Item No. **Report of the Head of Development Management and Building Control**

Address: 27 EASTBURY ROAD NORTHWOOD

Development: Proposed replacement dwelling and outbuilding at rear (Retrospective application)

LBH Ref Nos: **75352/APP/2023/2684**

PROPOSED FRONT ELEVATION
Scale 1:100

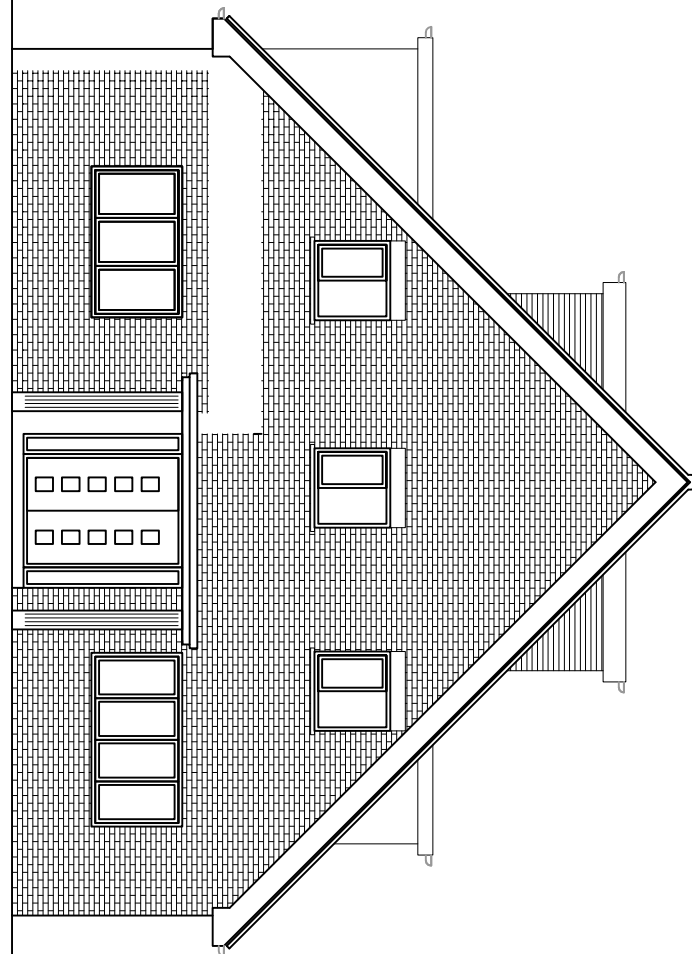
The window openings have been enlarged in size and dark brown windows installed. The windows

appear oversized in relation to the proportions of the dwelling and the type and size of windows found on neighbouring properties. On the front elevation, there are two larger windows at first floor level (instead of three smaller windows found on the original dwelling). The windows are all side hung unlike the original windows which also had a smaller top hung element. The new windows being of a modern design and appearance do not appear sympathetic to the typology of the Conservation area and are visually prominent when viewed from the street.

The lack of deep reveals and being flush with the brickwork, results in a poor finish and a flat and unduly prominent facade. Due to the size of the windows, when one or more of the windows are open, they would appear dominant and prominent. This would emphasise the incongruity of the material and design of the windows within the street scene.

The front porch is also shown on the plans to be 80cm wider than the porch allowed on the appeal scheme. The porch as proposed would extend a width of almost 40% of the width of the dwelling and project 2metres ahead of the dwelling. The porch measures 2.5metres in height which is the same height as the appeal scheme. The increased width of the porch would appear out of scale with the proportions of the dwelling. Further, a modern bulky cream colour front door with side windows has been installed. These elements provide additional contrasting features to the development and further exacerbate the visual incongruity of the development.

PROPOSED SIDE ELEVATION
Scale 1:100

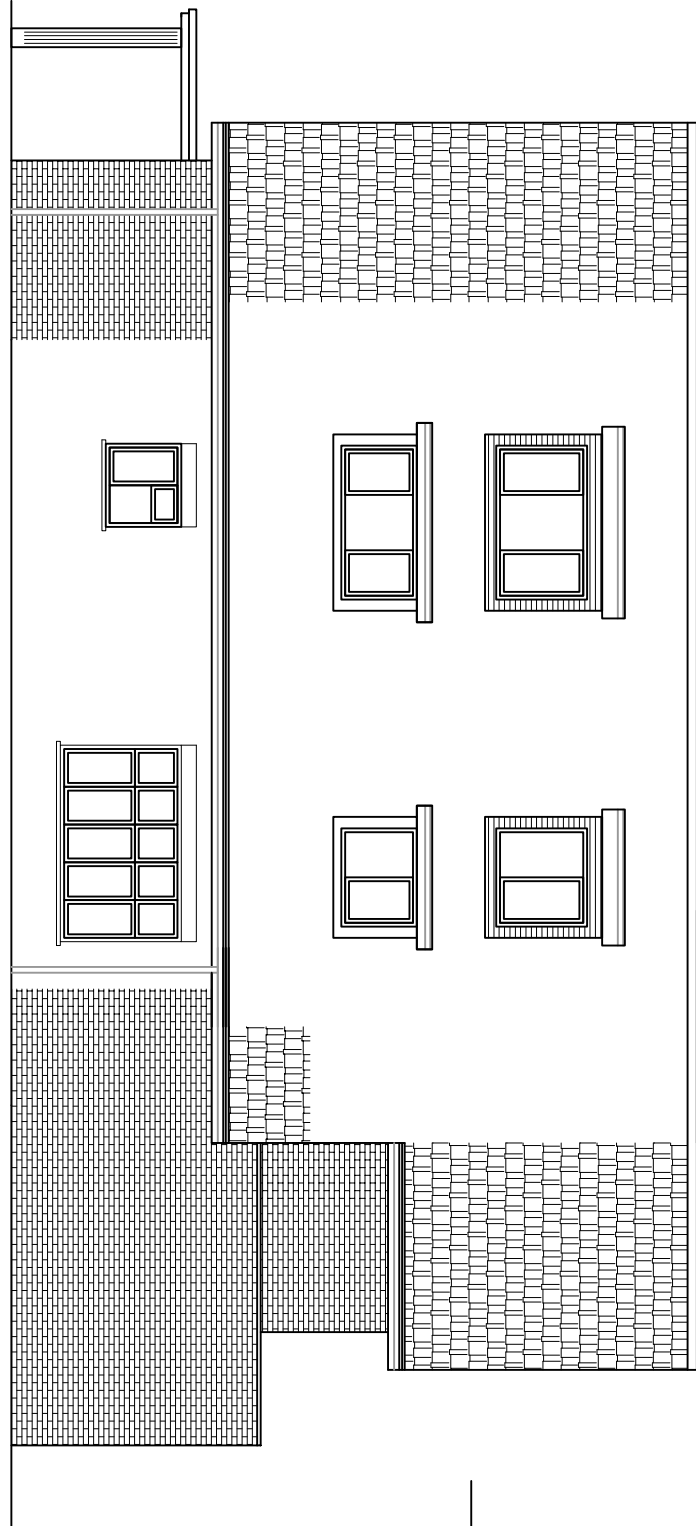
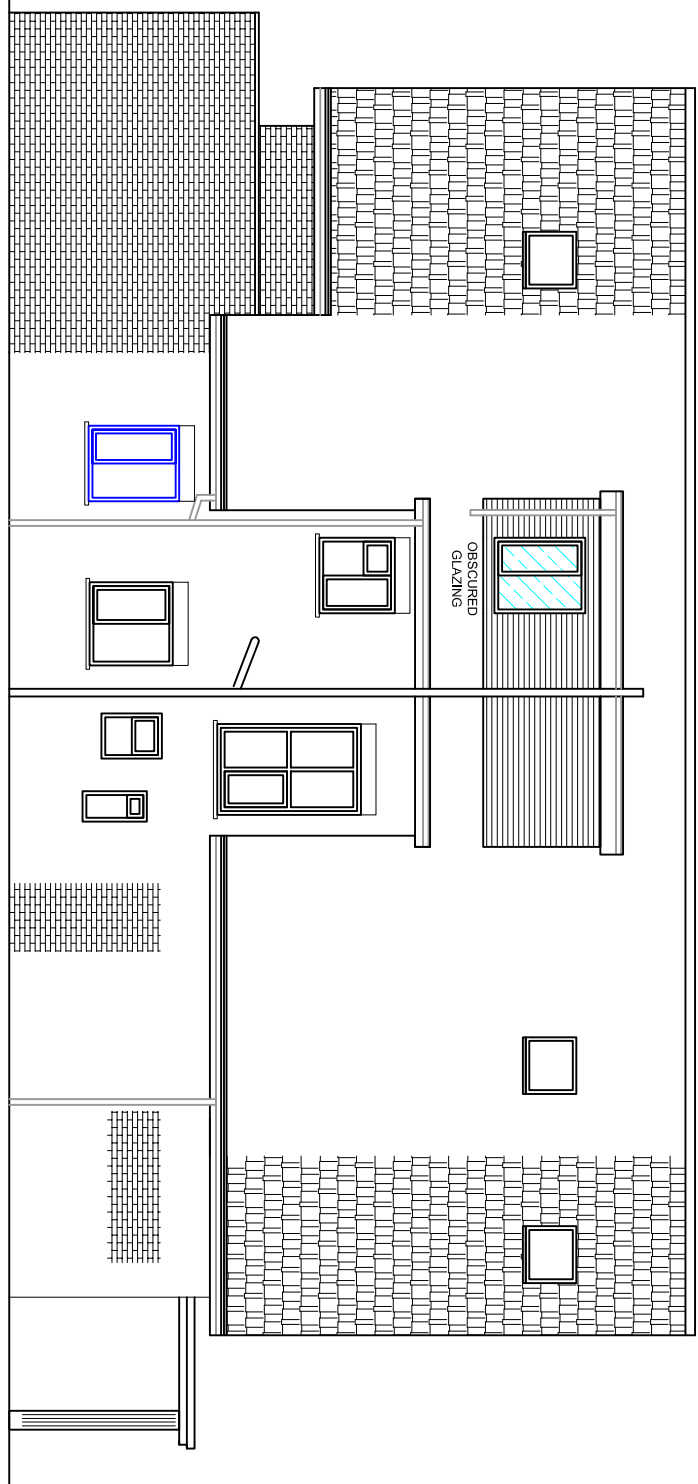
The current scheme also adds a further rooflight towards the rear of the south facing roof slope, which serves the first floor rear bedroom. It is also noted that one of the windows in the south facing dormer also serves the rear bedroom. Whilst the original dwelling comprised a two storey side element, it is noted that the two first floor side windows originally served a bathroom and the stairs. The current scheme would therefore introduce a side dormer window serving a habitable room, in this case, the rear first floor bedroom. The side dormer is located in proximity to the shared boundary and results in inter-visibility with the flank windows of the neighbour and directly overlooks the neighbouring property.

The two storey rear section of the dwelling projects almost six metres beyond the neighbours rear elevation at No.25 and the two rooflights located towards the rear section of the south facing elevation and the dormer window directly overlook onto the neighbours rear patio area, resulting in a significant loss of privacy and visual intrusion. Owing to the new rooflights and dormer window that serve habitable rooms, this is considered to represent a material worsening of the neighbours amenity. Obscure glazing of the side windows and rooflights in the south facing elevation could have been secured by condition in the event of an approval to mitigate some of the harm on the

The additional 2no rooflights in the north facing side elevation serve an en-suite and the stairs/landing to the loft. As these serve non-habitable rooms, these rooflights would not be harmful on neighbouring amenity.

The north facing dormer windows serve a bedroom and an en-suite. Noting that there were originally 2no side dormers facing north that both served bedrooms, in the same locations, it is considered that the neighbour would not experience any worsening with regards to overlooking or loss of privacy as a result of the works relating to the main dwelling, relative to the pre-existing situation.

The side dormers are located in similar positions and are of similar proportions to the existing side dormers and the two storey side element shown on the allowed appeal scheme. The roof and dormers walls have however been covered with grey slate effect concrete tiles which diverge significantly from the original brown clay tiles. The new slate effect tiles have a shiny texture and along with the new fenestration, contribute to making the development appear overly dominant in the street scene. It is evident that there are no examples of these same materials used on neighbouring properties.

Additional dark brown framed roof lights have been installed on both side roof slopes, which appear significantly larger than those shown on the proposed elevations. The number of roof lights is considered to be excessive and not appropriate within the conservation area. The proliferation of roof lights along both flanks of the roof slope detracts from the simple character of the building and adds an element of clutter and visual confusion to finished design. The series of the roof lights in particular, creates the appearance of a two tiered roof and adds to the poor quality finish of the development.

PROPOSED LOFT FLOOR PLAN
Scale 1:100

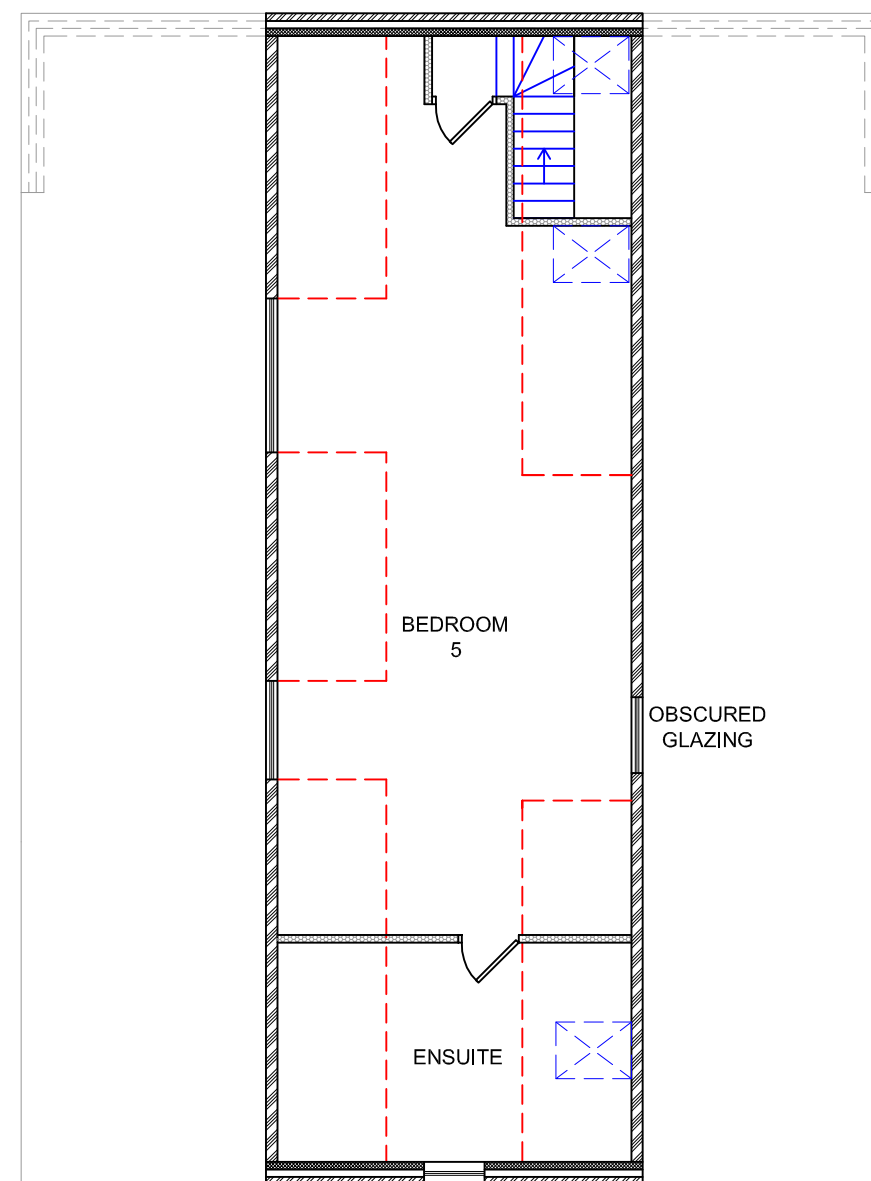
The rooflight towards the rear of the south facing roofslope was shown on the scheme allowed at appeal, however it was noted to serve an en-suite bathroom. Whilst the rooflight on the allowed scheme served a non-habitable room, the floor plans for the current application indicate that the room would be used as a prayer room.

Given its size, the prayer room is considered to qualify as a 'bonus bedroom' as it could be readily used as a bedroom by the current or future occupiers. The prayer room is served by a rooflight in the south facing roof slope.
